RE: SSD-10375 - IMPACTS OF PROPOSED PITT STREET NORTH OVER STATION: STAGE 2 DEVELOPMENT - CASTLEREAGH BOUTIQUE HOTEL AND NSW MASONIC CLUB

This submission has been prepared by City Plan Strategy & Development (City Plan) on behalf of the NSW Masonic Club. The NSW Masonic club is located at 169-173 Castlereagh Street, Sydney, adjoining the Pitt Street North Metro station (Figure 1).

**Figure 29** | Relationship between NSW Masonic Club building and proposal (Source: RtS)

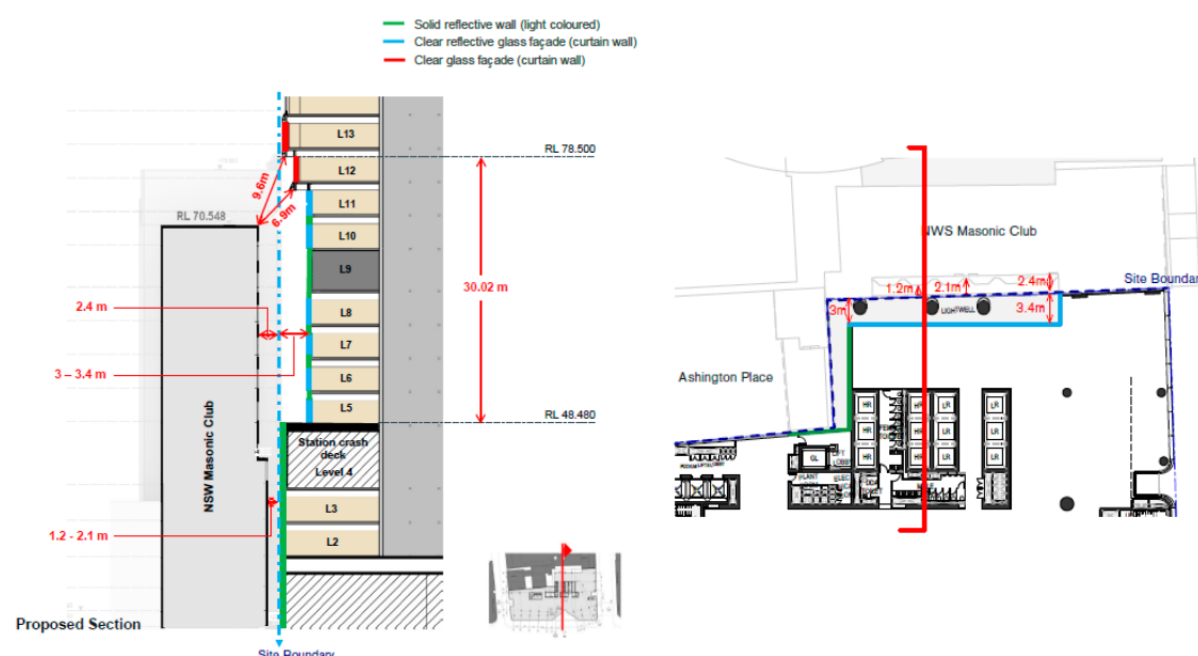
The proposed buildings setbacks to the lightwell have been prepared based on the Club being two storeys lower in height. This is significant because the size of the opening to the lightwell is significantly reduced, when the Clubs approved additional storeys are taken into account (Figure 8).

As described in Point 1, the opening to the lightwell has been designed on an erroneous understanding of the Club's development capacity. The proposed setbacks are not sufficient to protect light access to the lightwell when the approved development capacity of the Club is taken into account. It is important to note that the proposed lightwell also includes three transfer columns which land adjacent to a number of windows and are likely to affect light penetration into the lightwell and adjacent rooms.

The proposed development is therefore inconsistent with Condition B2 of the Concept Approval and cannot be approved in its current form. We request therefore that proposed levels 12 - 14 are setback to achieve the intended opening to the lightwell as is shown in Figure 8.

**Figure 31 | Car stacker and Loading dock layout (Source: RtS)**

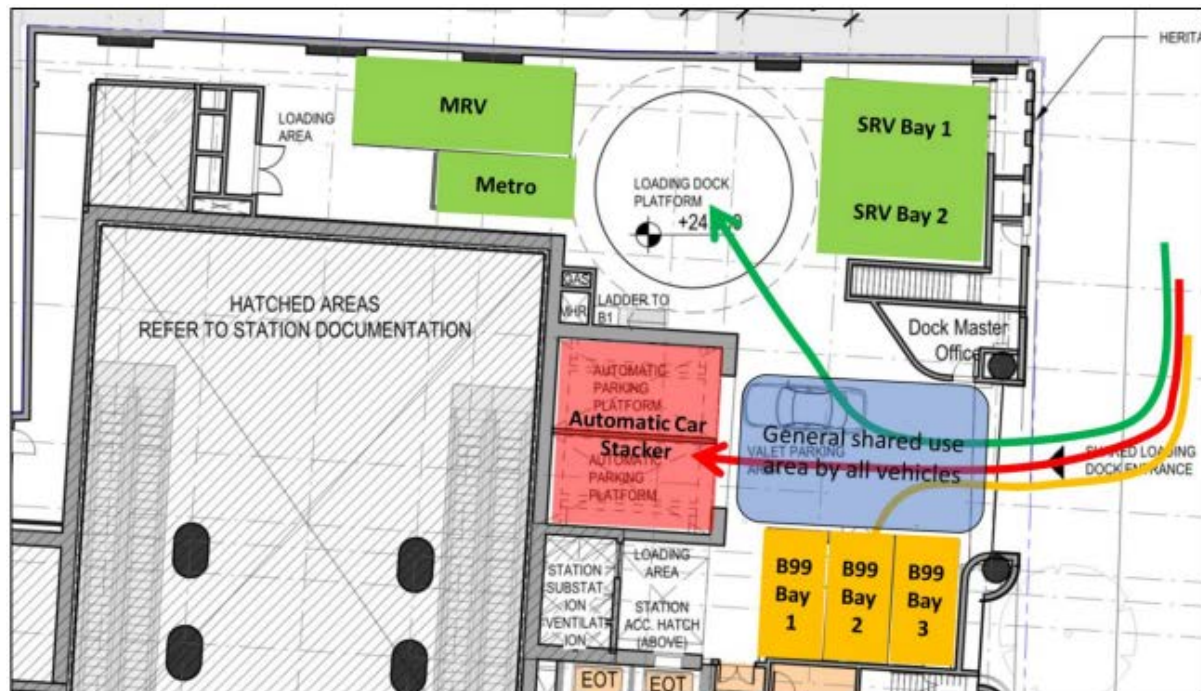
The proposed loading and parking facilities are located in the north-eastern corner of the building, adjoining the Club. We therefore ask that the Department gives specific consideration to the operation of those spaces and the plant therein, and how they will impact on the acoustic privacy and amenity of the Club, the Hotel rooms and the ground floor café.
